Your Ref: OWPC6385
Our Ref: AW/163/15/HH 15-06-2015
Please ask for:
Mr D Vick

3 storey extension including moving living area to first floor level & 2 bedrooms with en-suite in the roof.

1 The Dunes Aldwick Bay

NEW WEST ELEVATION

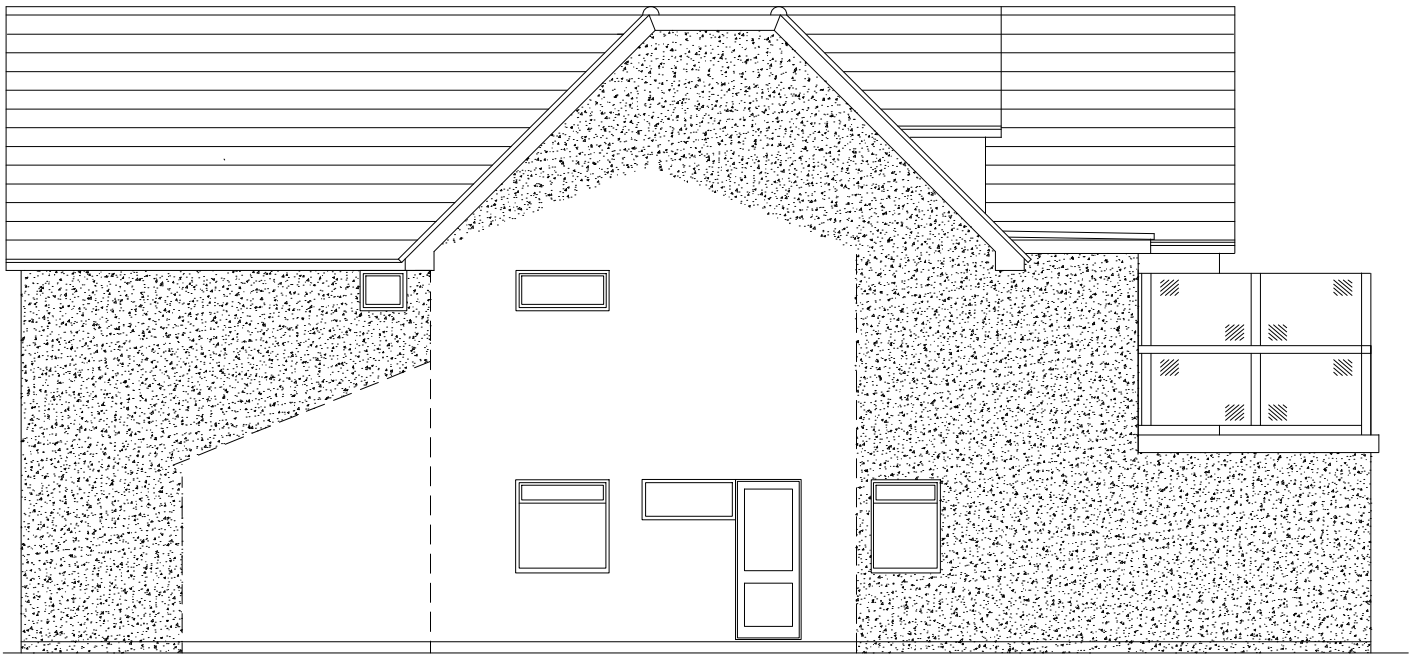
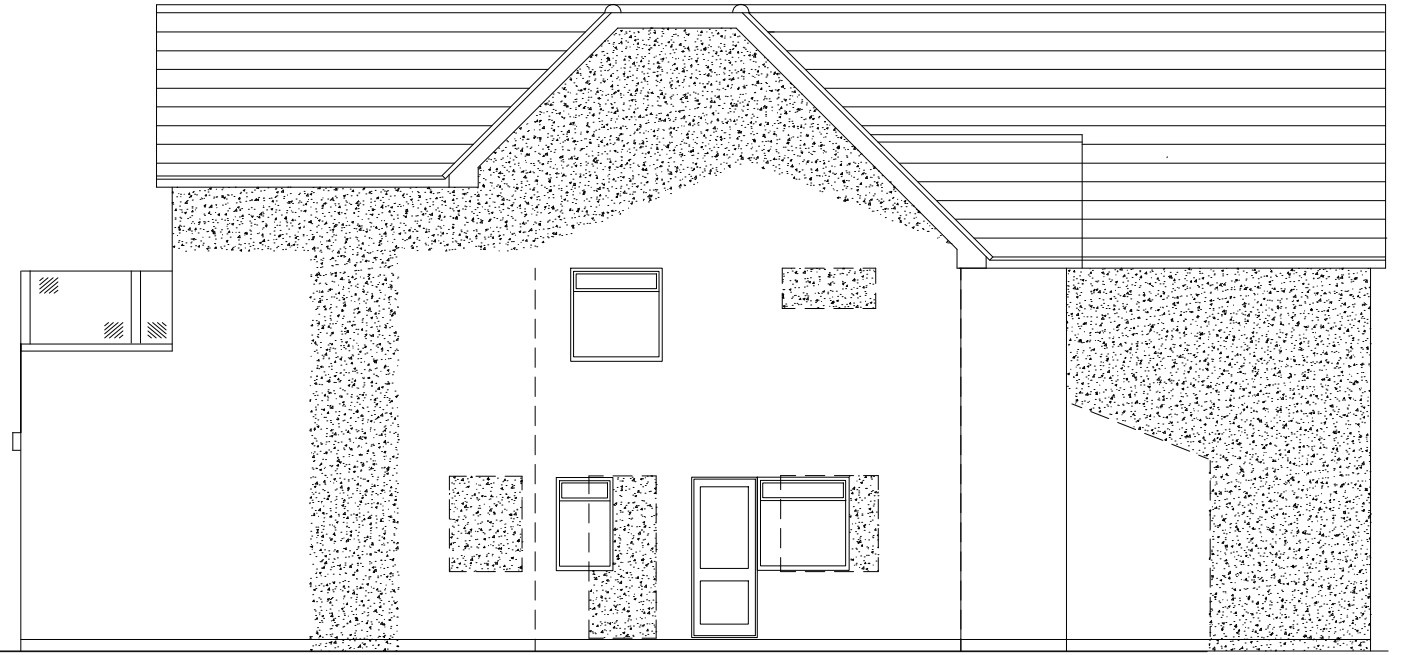
The proposed development impacts my property to a large extent. The new West Elevation is adjacent to my East Elevation and the proposal increases the length of the ground floor from 9 metres to 18 metres and the first floor is increased from 5.7 metres to 15 metres and a new gable end is added that is 30% wider at the base and rises 2 metres above the existing roof line to accommodate the addition of a second floor. These changes combine to restrict the light to my ground floor rooms and severely reduce my view of the beach and sea to the East and South East from the first floor and will put my first floor sun room and balcony in the shade till mid day.

The proposed elevations include gable ends to the East, West and North. This is out of keeping with other properties in The Dunes and along other beach front houses where hipped ends are used. Such a modification to the proposal would go some way to reducing the impact of the increased height and lessen the reduction in light. The inclusion of hipped ends was part of the planning applications for numbers 2 and 3 The Dunes in recent years.

LOCATION PLAN

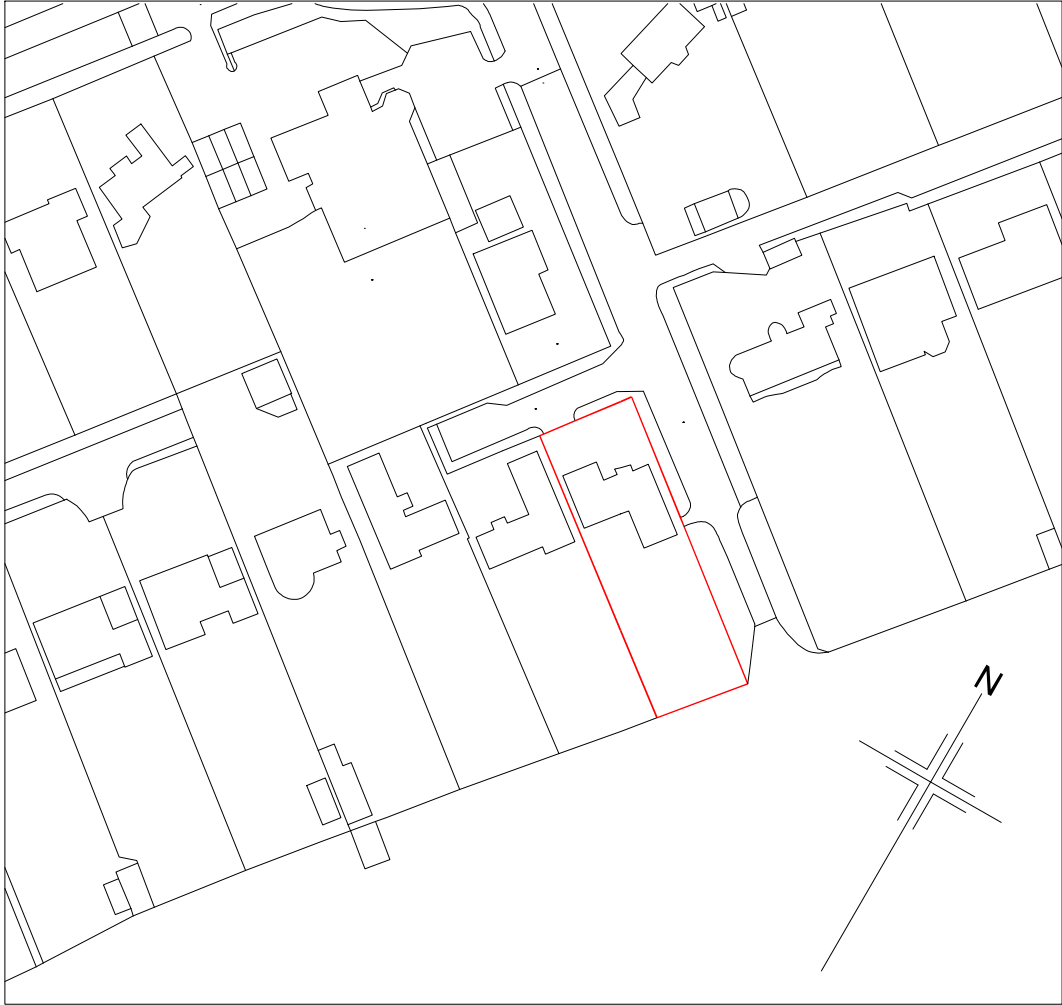
The site plan drawing 5 of 6 in the planning application is inaccurate in so far as the foot print of numbers 2 and 3 The Dunes are pre changes that have been undertaken in the last 5 years and thereby do not fully show the impact of the proposed extensions to number 1 The Dunes.
